PROPOSED ROADWAY PLANS FOR JUDGE ORR ROAD RV PARK & STORAGE EL PASO COUNTY, COLORADO

JANUARY 2022

**DRAINAGE, GRADING & EROSION CONTROL PLAN**

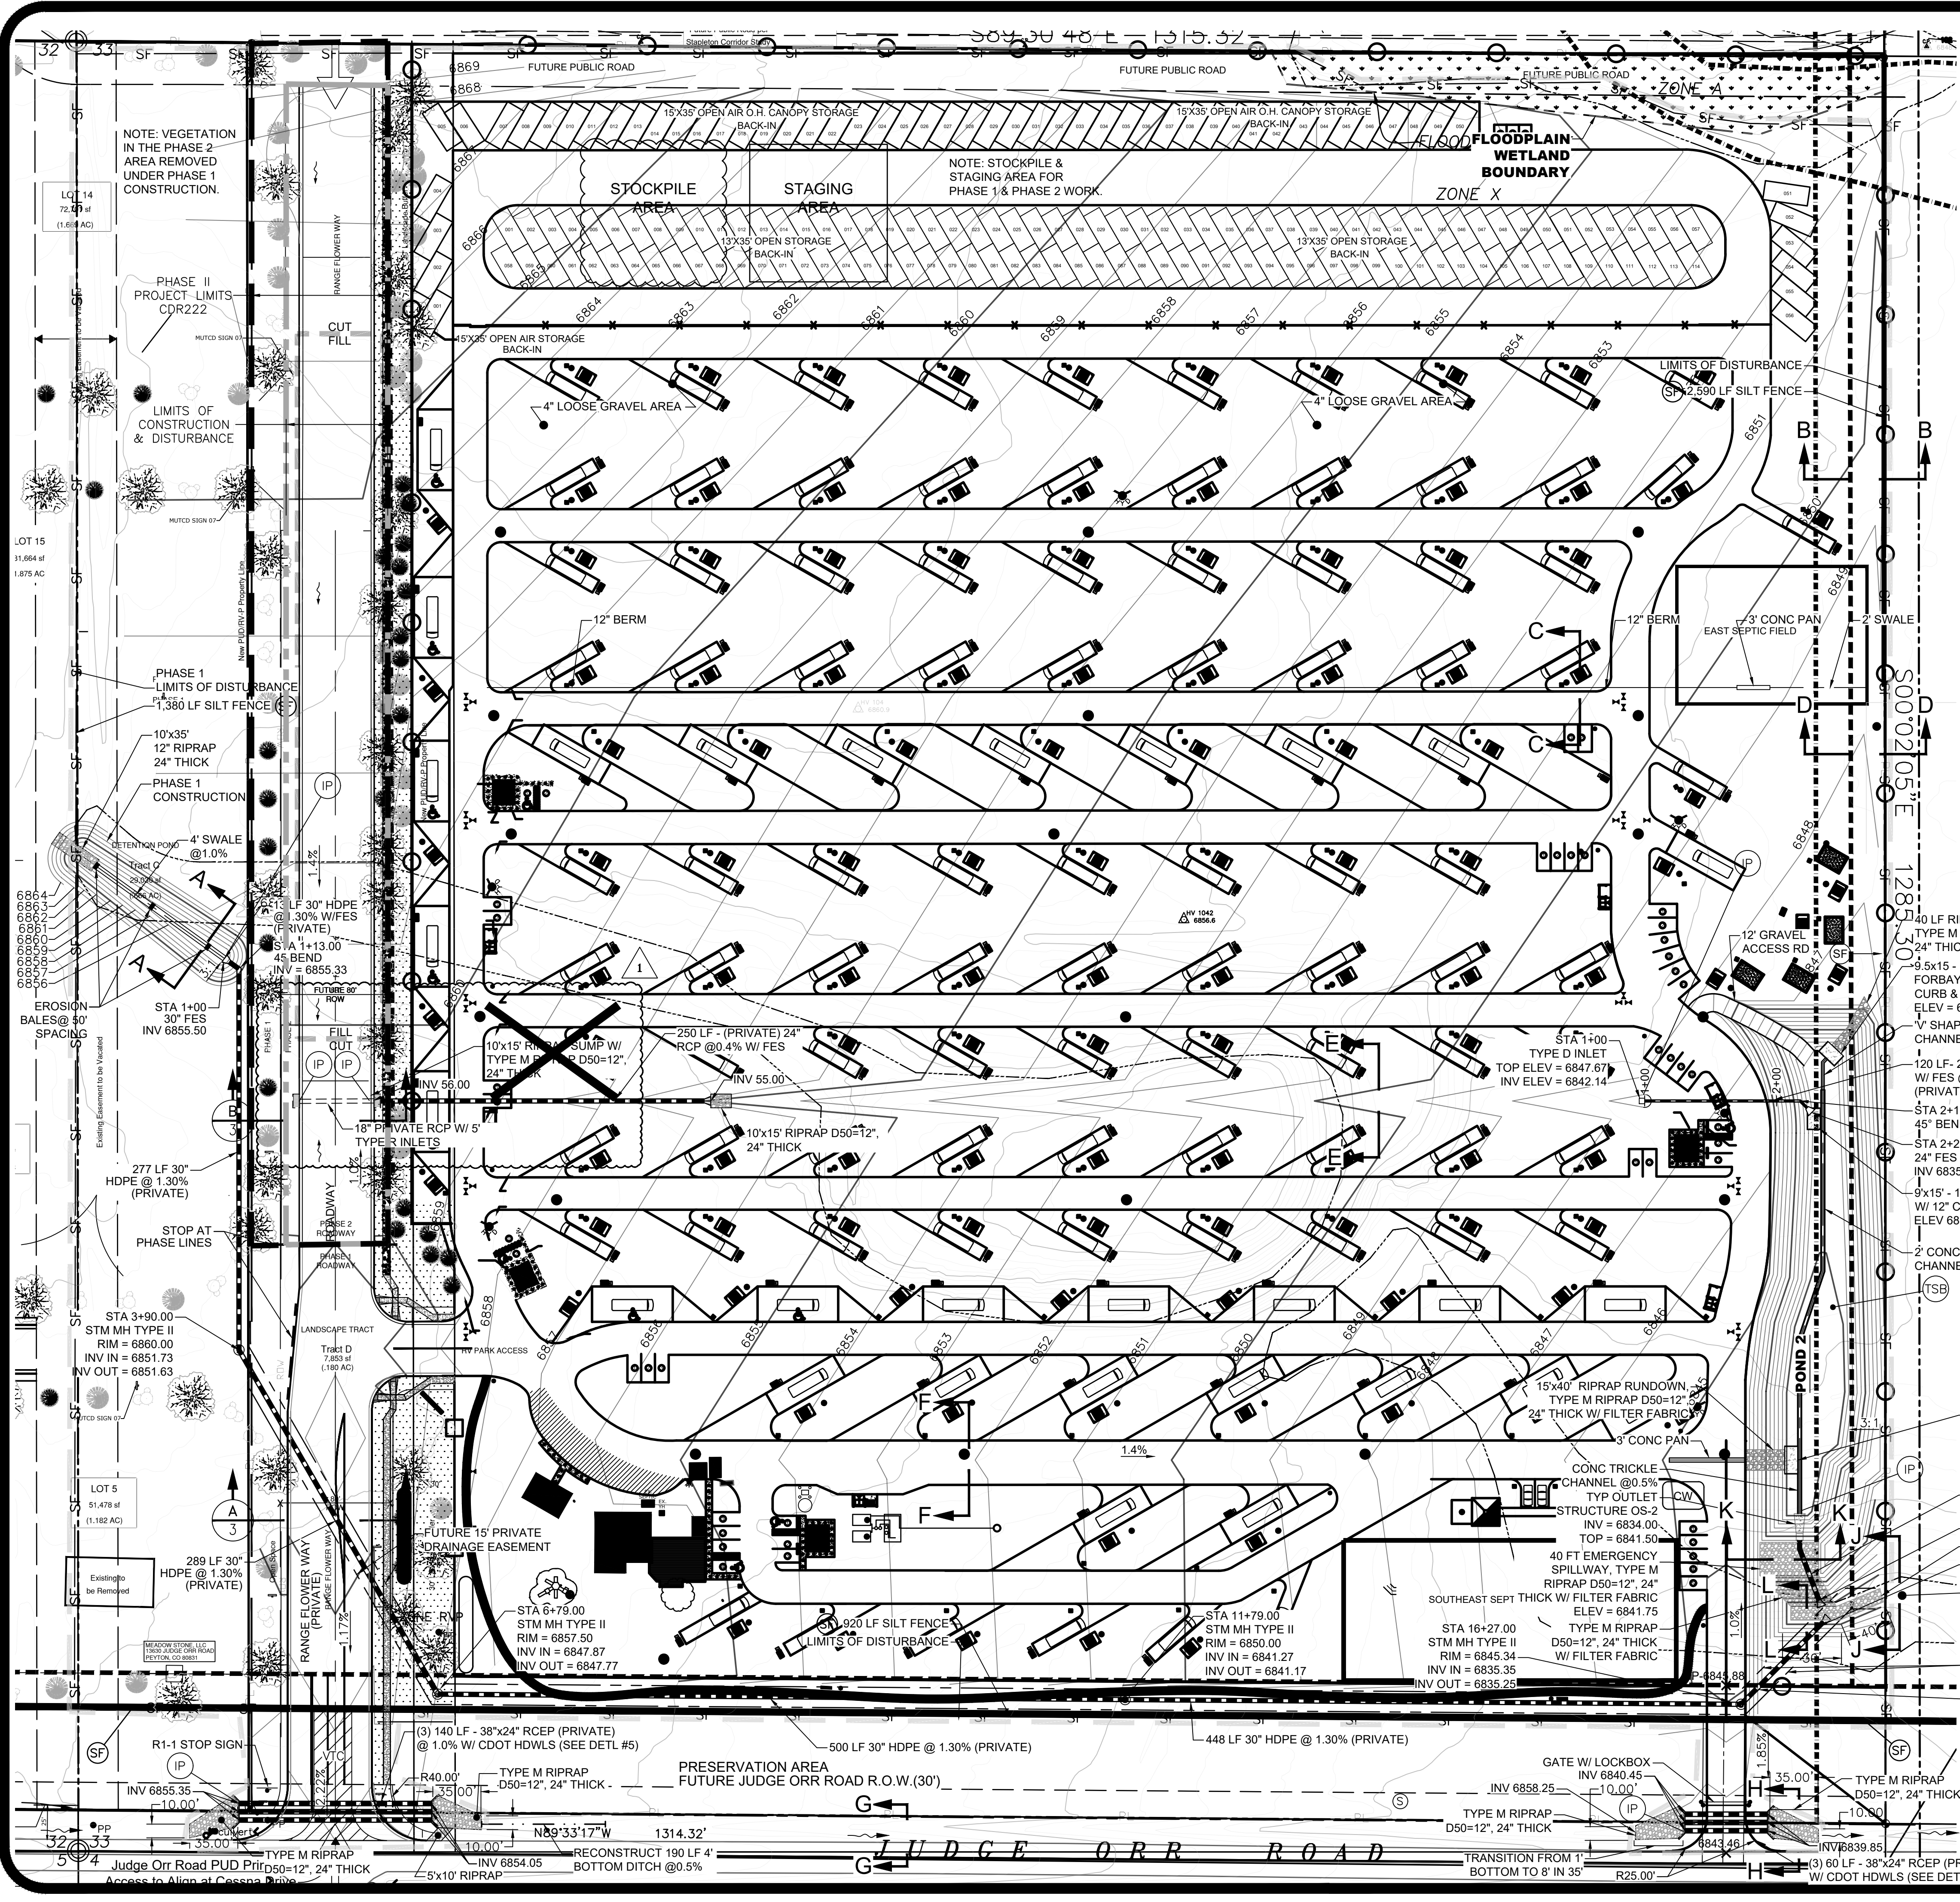
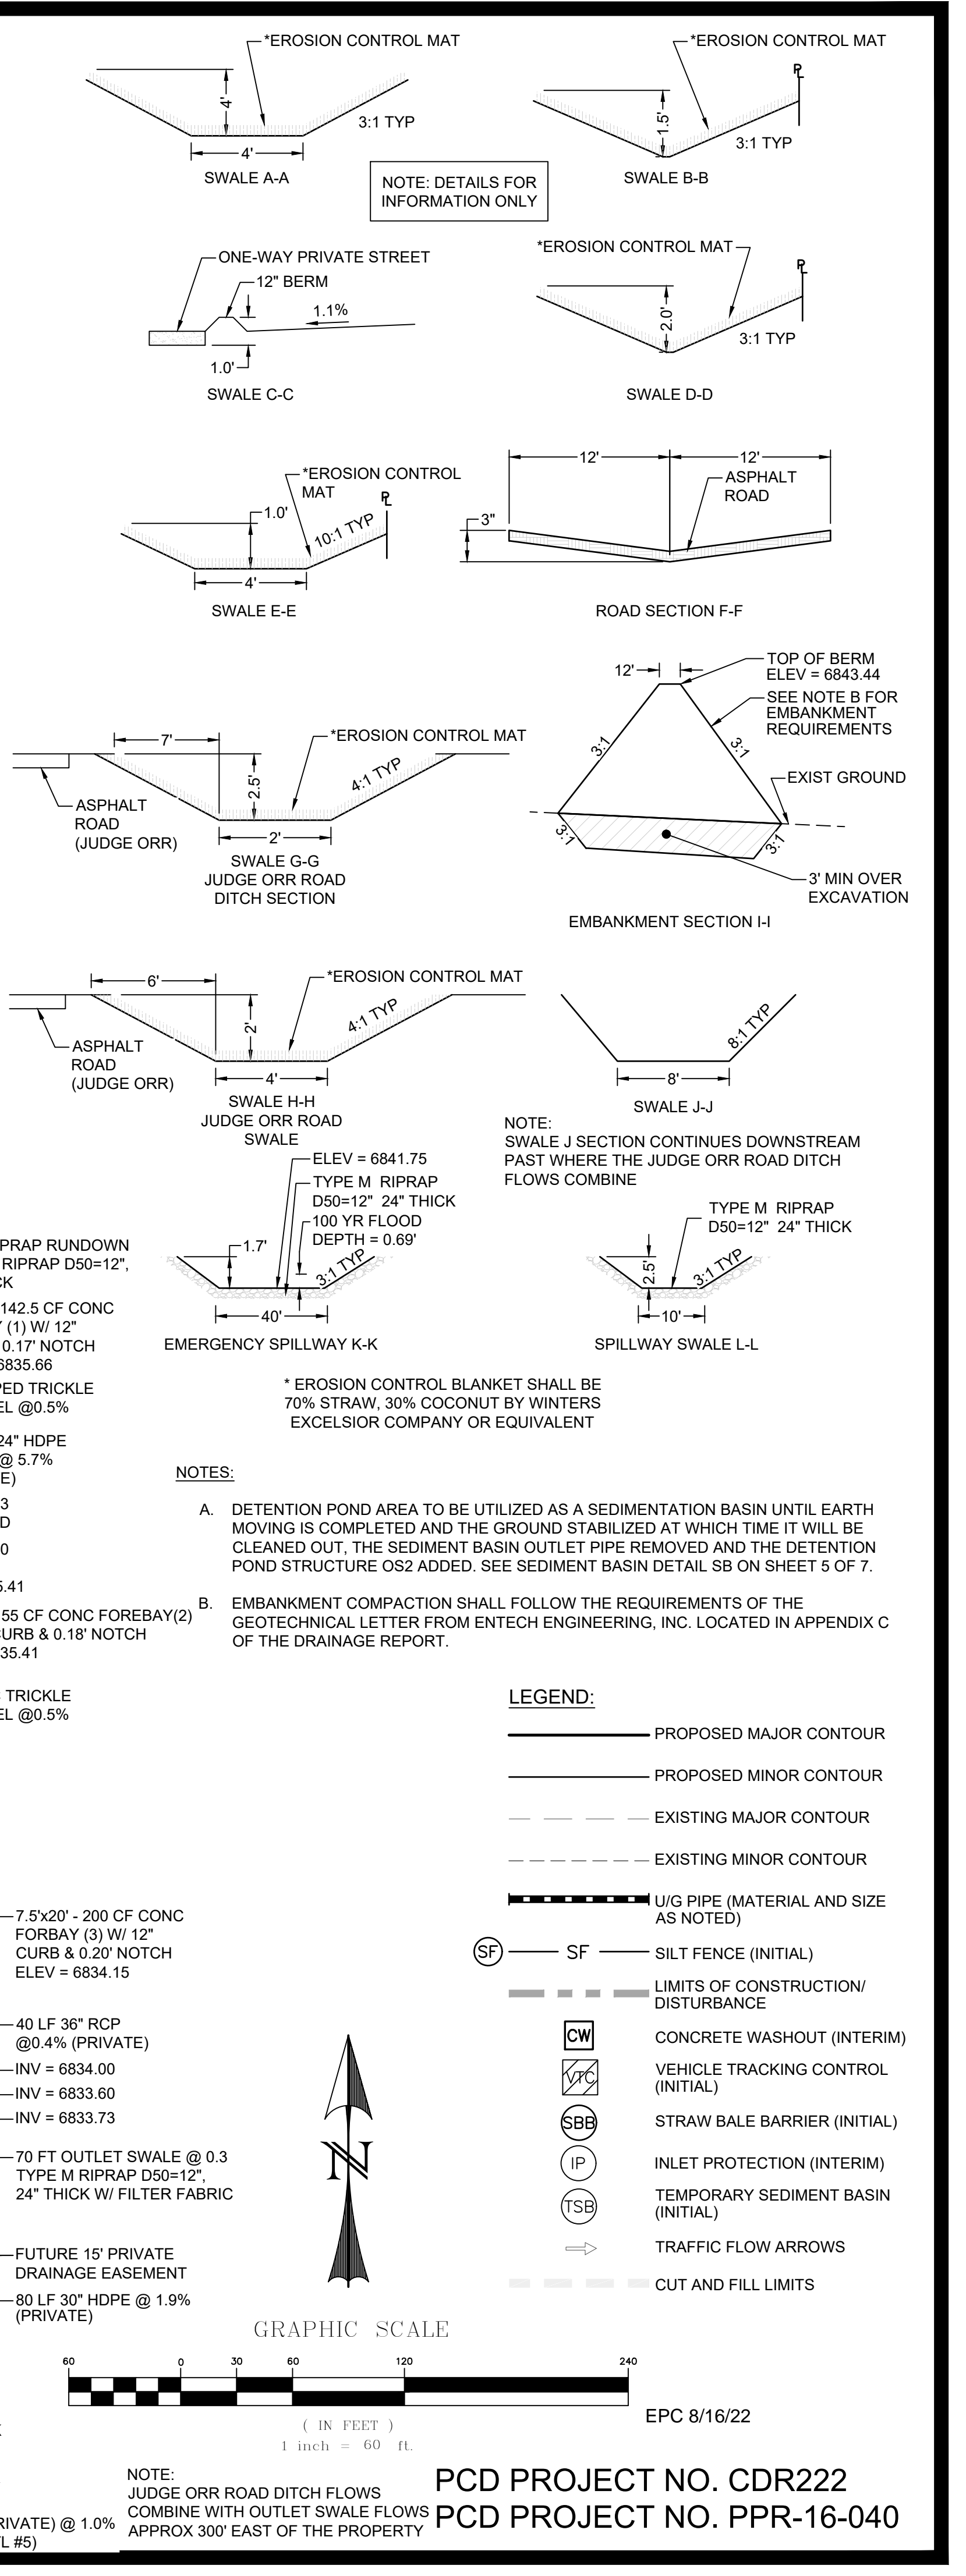
Add a grading and erosion control plan for the proposed roadway extension.

Show both existing BMPs that are to remain that were installed with the site plan application (PPR1640) and new BMPs to be installed with the proposed extension.

Plans shall differentiate between the two.
